CITY OF ALBUQUERQUE

April 4, 2023

Re: Dia De Las Baristas
4915 Lomas Blvd. NE
Traffic Circulation Layout
Architect's Stamp 03-08-23 (J17-D006)

Based upon the information provided in your submittal received 03-15-23, the above referenced plan cannot be approved for Building Permit until the following comments are addressed:

SOLID WASTE SITE PLAN

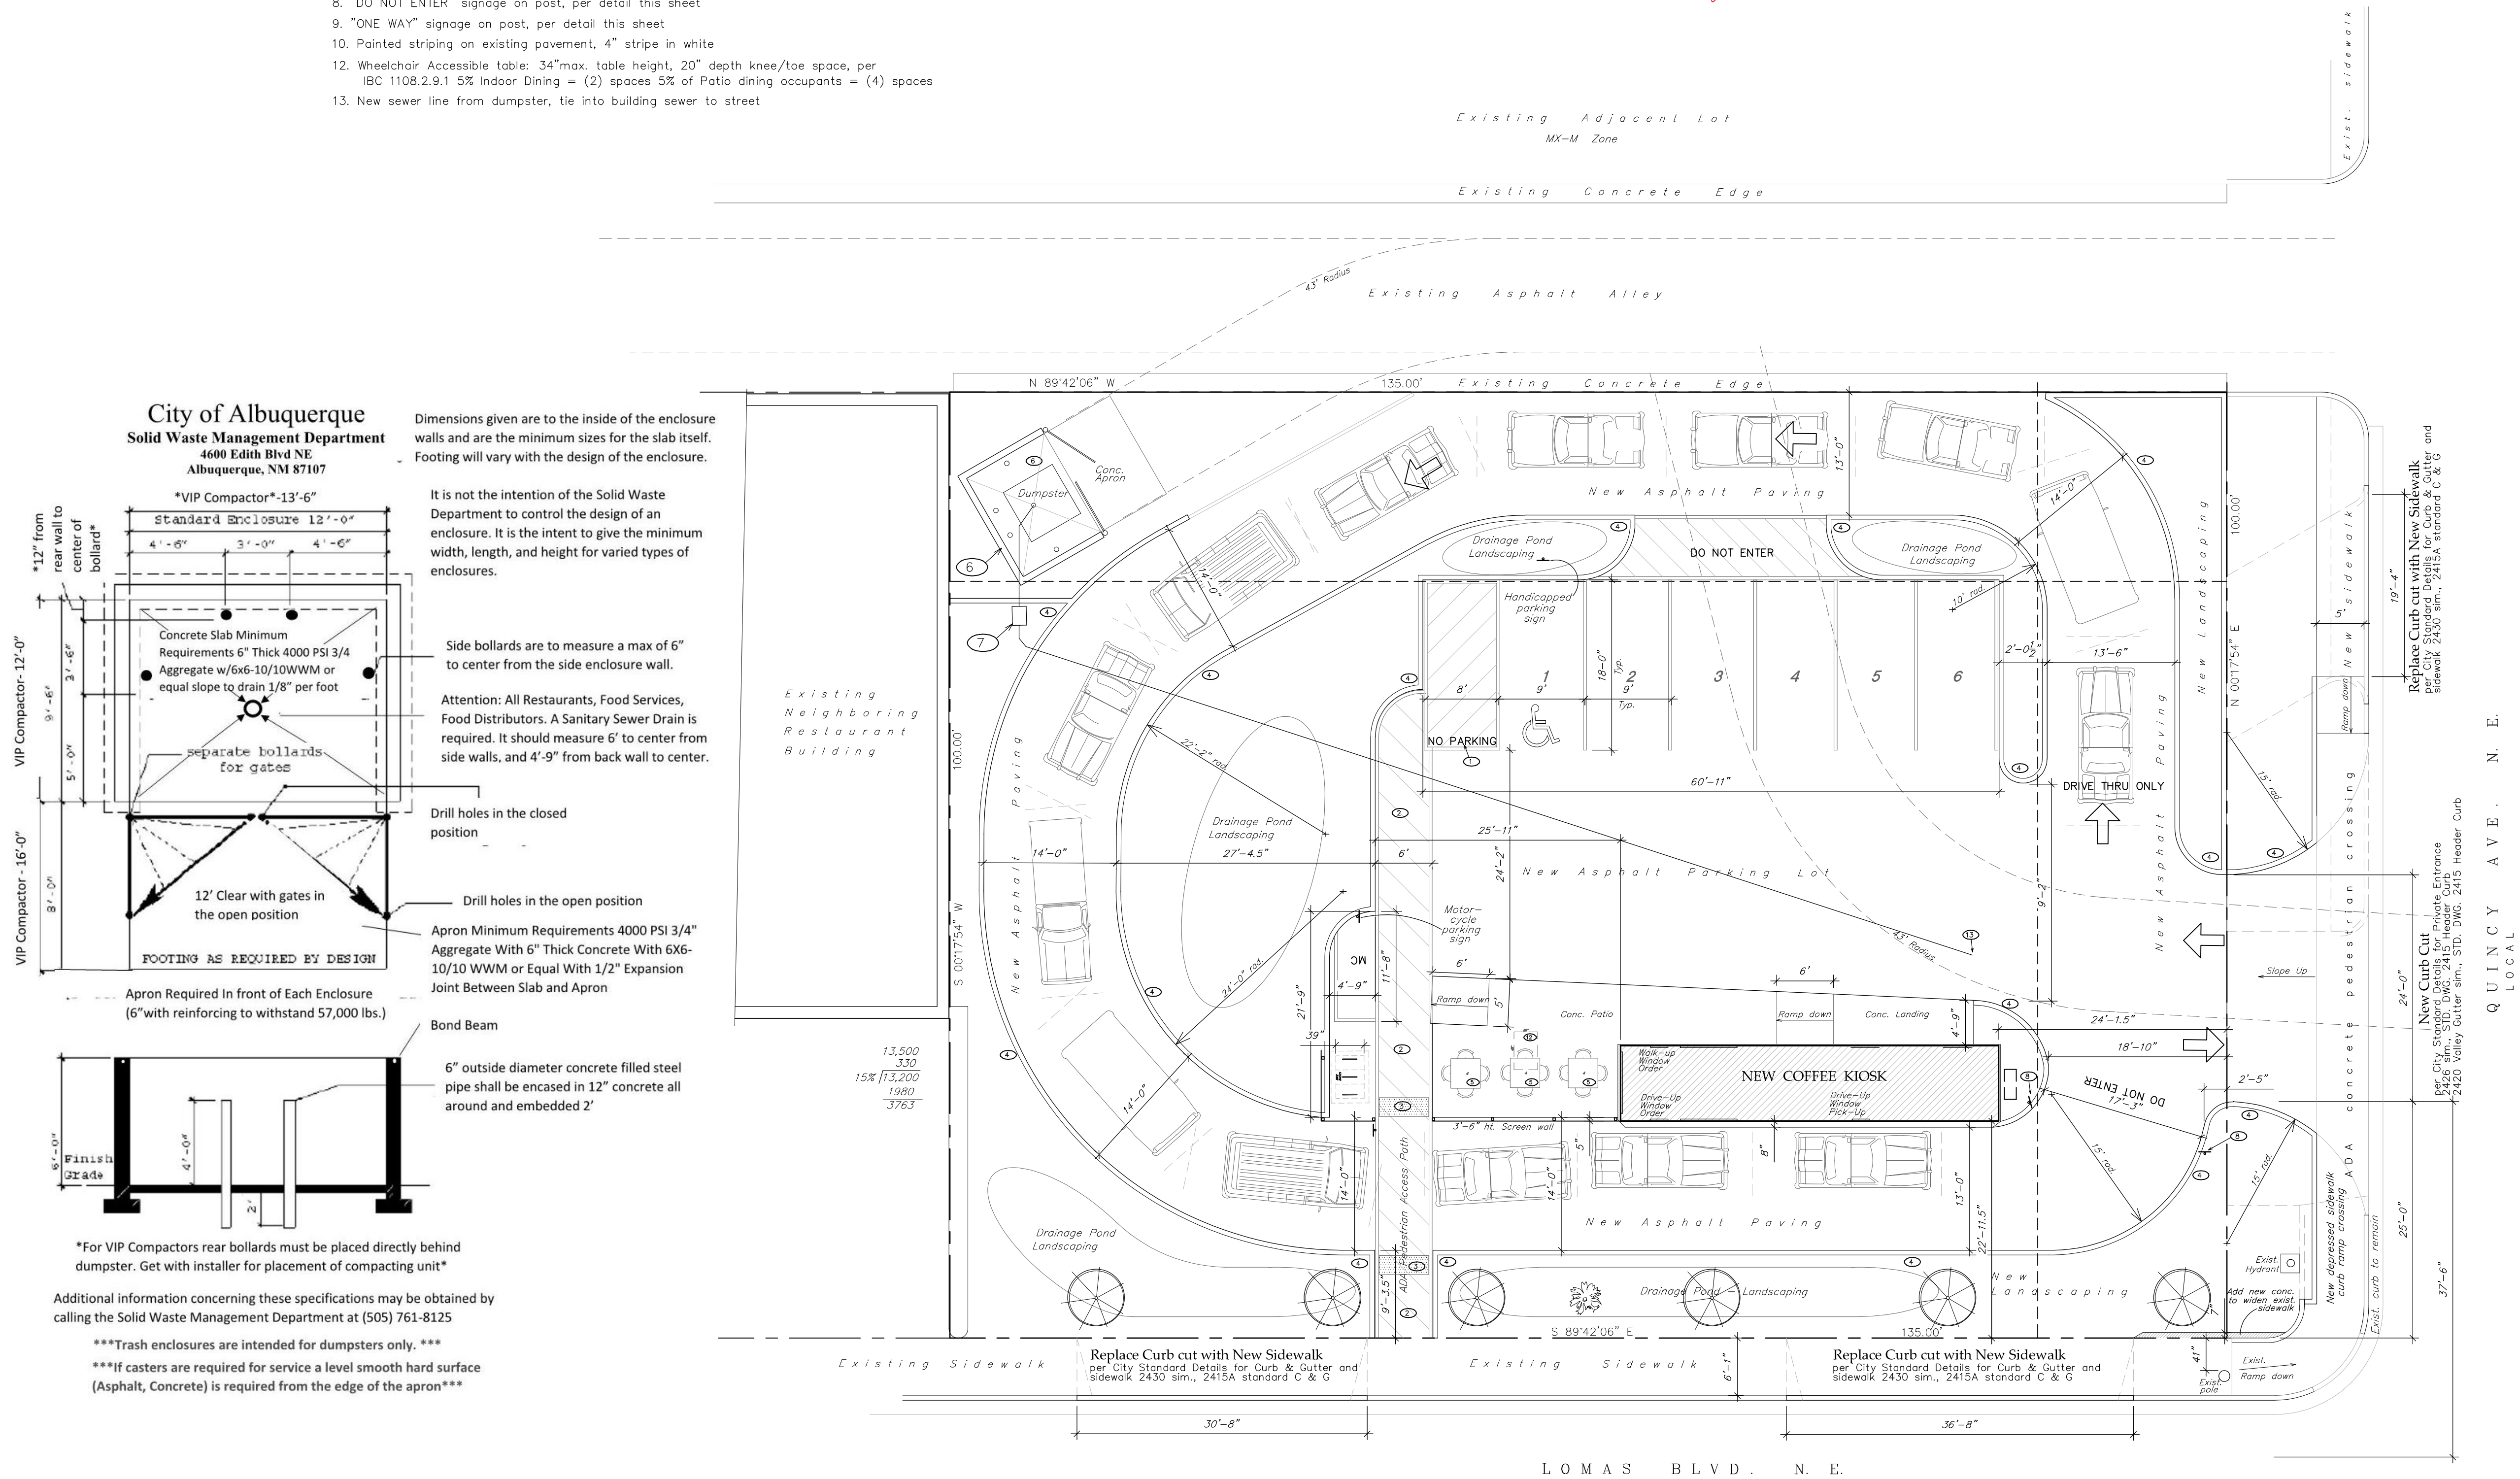
1. Identify all existing access easements and rights of way width dimensions.
2. Identify the right of way width, medians, curb cuts, and street widths on Lomas Blvd. NE and Quincy Ave. NE.
3. Per Ernest Armijo instruction, please close the edge of the drive-thru on the north side of the site. (suggestion: close it with a curb or barriers curb).

4. Please provide sidewalk easement for this proposed concrete to widen the existing sidewalk. For sidewalk easement, please contact Carrie Mouck @ camouck@cabq.gov

5. ADA curb ramp at the corner of Lomas and Quincy must be updated to current standards and have truncated domes installed.
6. Show on the site plan the radius for this area

7. Please provide "One Way signs and pavement marking at the beginning of the drive-thru.
8. Curbing or Barriers curb should be installed in this area

9. Show the clear sight triangle and add the following note to the plan: "Landscaping and signage will not interfere with clear sight requirements. Therefore, signs, walls, trees, and shrubbery between 3 and 8 feet tall (as measured from the gutter pan) will not be acceptable in the clear sight triangle."

10. Please provide details for all the proposed interior ADA ramps. And note that the max. running slope is 8.2% and max. cross slope is 2%.
11. Please provide a copy of Fire Marshal approval.
12. Please provide a letter of response for all comments given.
13. Traffic Studies: See the Traffic Impact Study (TIS) thresholds. In general, a minimum combination of 100 vehicles entering and exiting in the peak hour warrants a Traffic Impact Study. Visit with Traffic Engineer for determination, and fill out a TIS Form that states whether one is warranted. In some cases, a trip generation may be requested for determination (**Contact Matt Grush: mgrush@cabq.gov**).
